**Case Officer:** Wayne Campbell

**Applicant:** Mr James Doran

**Proposal:** Discharge of condition 5 (Site Development Scheme) of 20/02060/F  
(Appeal ref APP/C3105/C/21/3268454)

# SITE LAYOUT PLAN

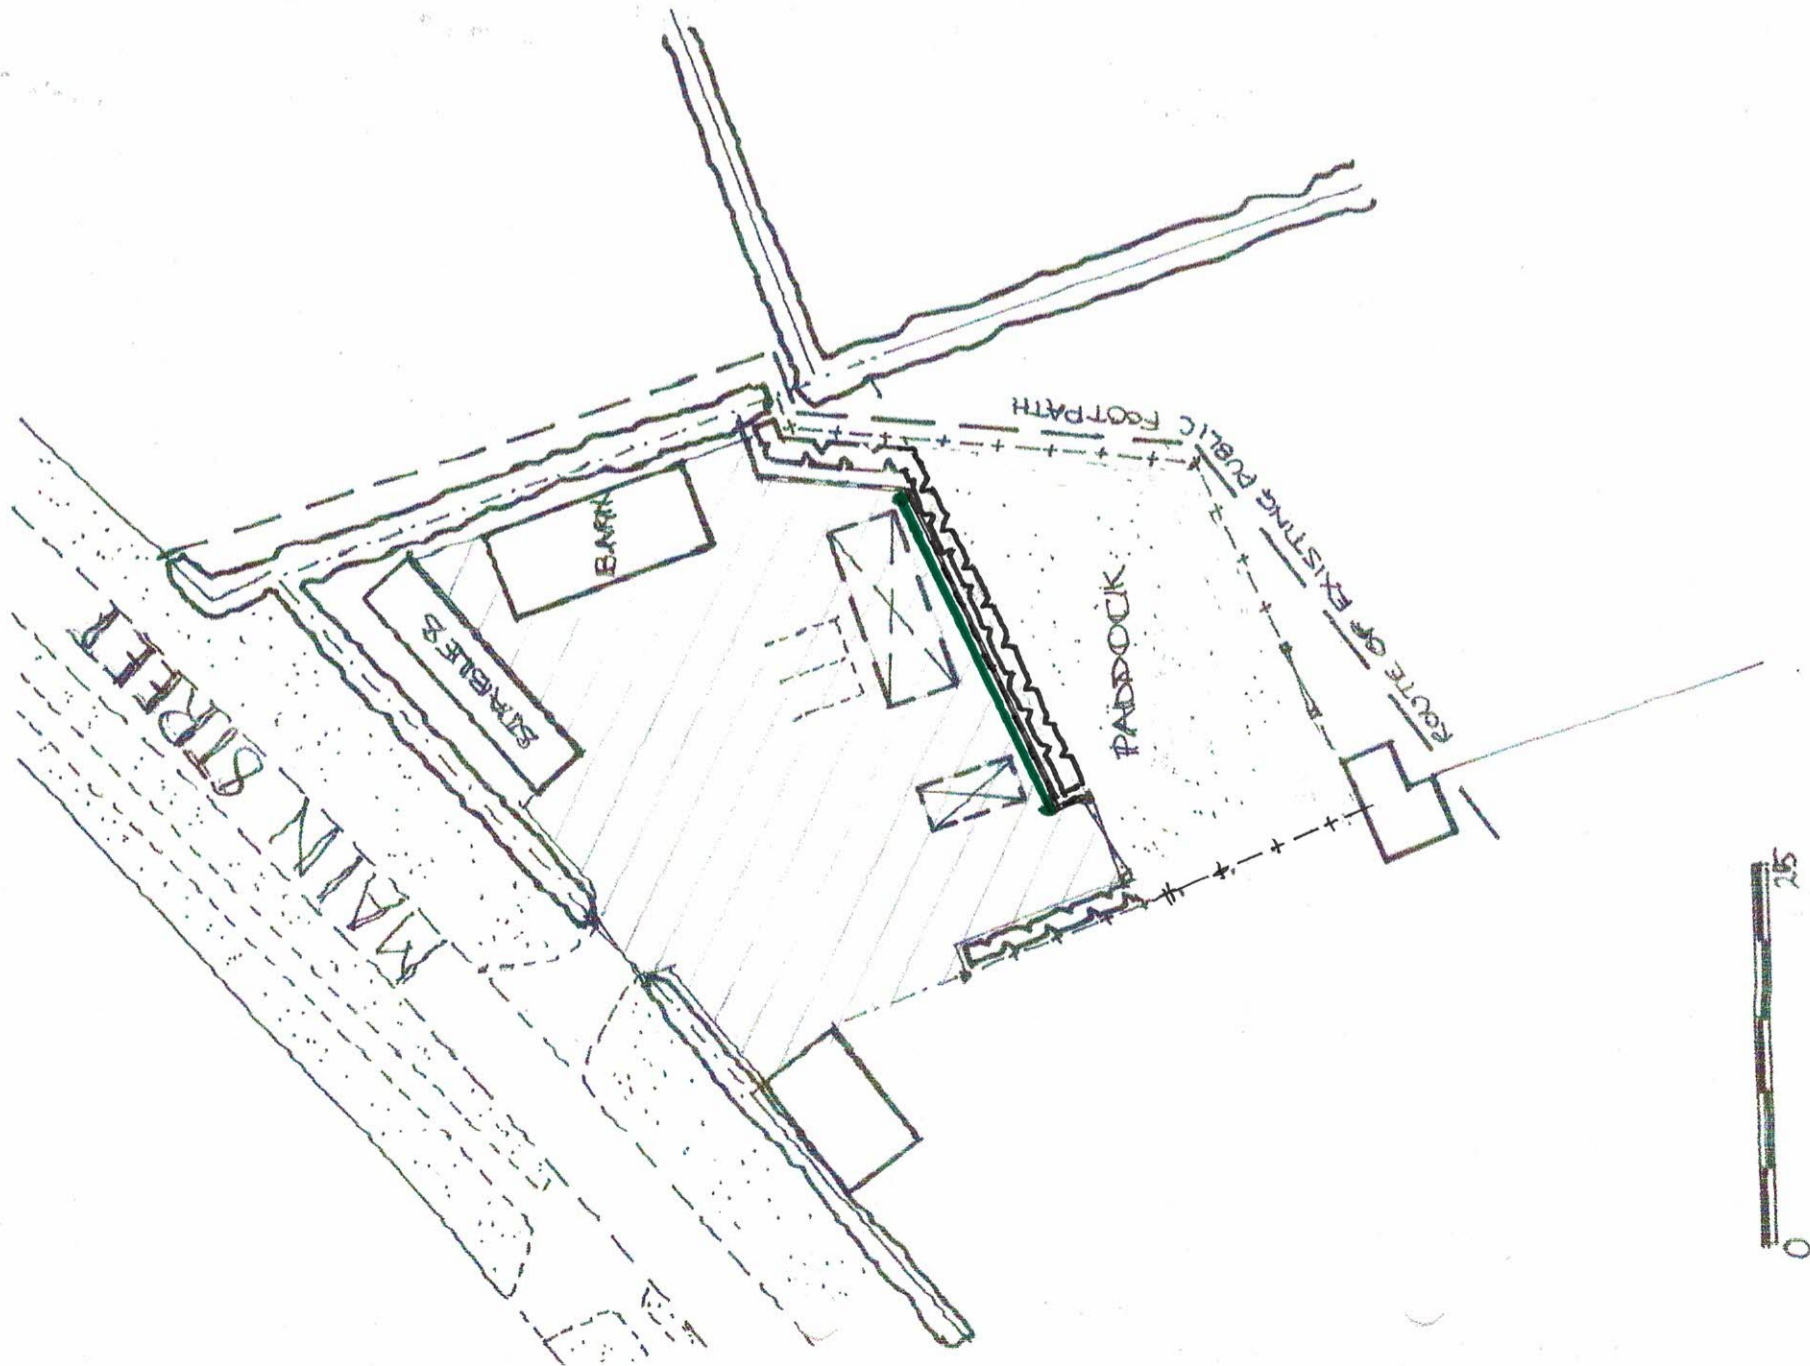
5.3. OCC RIGHTS OF WAY: Objection. Bourton Footpath 8 runs through this site but the amended plan does not show the correct definitive line of the footpath. But instead shows only the permissive route. The proposed screen fence and tree/hedge planting is welcomed, as it is hoped this will separate the dogs on site from the footpath users. However, I believe the screen fence and planting on the amended proposal may obstruct the definitive line of the footpath (not shown on the plan), particularly the planting. Adjusting the layout of the planting and screen fence where the footpath enters the site would resolve this issue.

6.3. The details submitted show the provision of a large area of hardstanding formed from gravel and hard core. The area of the hardstanding has expanded from that area used as hardstanding at the time of the appeal. The area of further hardstanding is not in accordance with the area considered by the Inspector during the consideration of the appeal and as such represents a further expansion of works not covered by a condition but which would itself require planning permission.

6.4. As a result of this further expansion of hardstanding the area allocated for the mobile home and the touring caravan has also expanded allowing for a larger area of development land than considered under the appeal. The details of the hardstanding and the siting of the caravans is therefore not considered to comply with the requirements of the appeal decision / condition.

6.6. In addition to this the application states that the hedgerow would also contain a number of trees in the form of 40% Silver Birch, 40% Mountain Ash and 20% oak. It is not how clear where these trees are to be located on the site. The plan submitted

fails to clearly identify where the trees would be located on the site and as such the applicant has failed to clearly demonstrate the landscaping to be used on the site.

- 6.7. The information provided with the application is confusing in that two sets of fences are shown on the plan but only one fence is within the area of the red line plan considered as part of the appeal. The 2m high fence allocated along the edge of the appeal site would appear as a hard edge to the site which would be seen from the public right of way which runs along the southern edge of the site. Although it is accepted that the proposed hedgerow is to be located immediately alongside the new fence it is not considered that adequate space has been shown to allow the hedgerow to grow and mature. The fence would therefore remain as a hard urban edge to the site.

- 6.8. The second fence shown on the plan is that of a post and rail fence which had initially shown to be enclosing an area of amenity space. The post and rail fence is an existing fence of around 1.5m in height and encloses an area of land *which the applicant is gradually covering with hardstanding without consent*. This second fence is not within the area of the appeal decision and although shown on the plan and in the covering letter as a fence to be considered as part of the discharge of condition is not considered to comply with the requirements of the condition but results in the extension of the area of built form beyond the red line plan. In addition to this, the post and rail fence cuts across the route of the existing public right of way resulting in a diversion of the route around the southern edge of the post and rail fencing. An objection to this diversion has been raised by the County Rights of Way Officer. For these reasons it is not considered that the applicant has complied with the requirements of the condition.

- 6.9. As initially submitted the details provided showed an area of amenity space allocated within the area outside the appeal area and enclosed by the post and rail fencing. The Council advised the applicant that this was not acceptable as the area of land is outside the area considered under the appeal and would represent a further extension of residential, use in the countryside which in itself would require planning permission. The applicant therefore changed the description to state this area was used as paddock land which although itself would be acceptable is likely to be used as amenity space by the residents of the caravans on the site.

- 6.10. Notwithstanding this point the removal of this area as amenity space has not been replaced with any new area of amenity space on the site. It is considered that the site could provide an adequate area of amenity space with soft landscaping to the area along the western area of the site. As such the applicant has failed to demonstrate adequate amenity space within the site area as required under the terms of the condition.

- 6.13. With regards to surface water drainage this is more of an issue than the foul drainage in that the site is covered as an area at threat of surface water flooding. The applicant has stated that they intend to implement a surface water drainage system by way of a soakaway using a layer of gravel on a sub-base of clean hardcore and a base of crushed aggregate. A filter drain located to the immediate rear of the mobile home would be provided to take rainwater from the mobile home, intercept any excess surface water run-off, provide on-site storage of storm water and assist the infiltration of surface water into the ground.

- 6.14. In considering this approach the Council's land drainage officer has requested further information to assess the drainage of the site. The comments made state that due to the nature of the site being in an area of mid risk of flooding by surface water would infer that *the site may not be suitable for soakaways*. It is further stated that the surface water flood risk must be mitigated by a compliant scheme. In proposal as submitted the Council considers that the system of infiltration drains *does not in itself represent an acceptable method of disposal*. The infiltration drainage must be discharged to a system of soakaways that has been proven would be successful.

- 6.15. To determine what method of drainage would be acceptable on this site it is recommended that the applicant needs to provide further information. This information would be in the form of soakage tests in strict accordance with BRE 365 at the proposed locations of the soakaway(s). Soakaways, if they are proved to be feasible, must then be designed and constructed in compliance with BRE 365 with details to be submitted to the Council for approval. The applicant has been made aware of this requirement, but no further information / test results have been provided by the applicant. If a compliant design cannot be achieved due to ground conditions a positive discharge to a suitable ditch/watercourse will be required for which a Land Drainage Act consent will be needed. As such it is not considered that the applicant has adequately complied with the requirements of the condition.
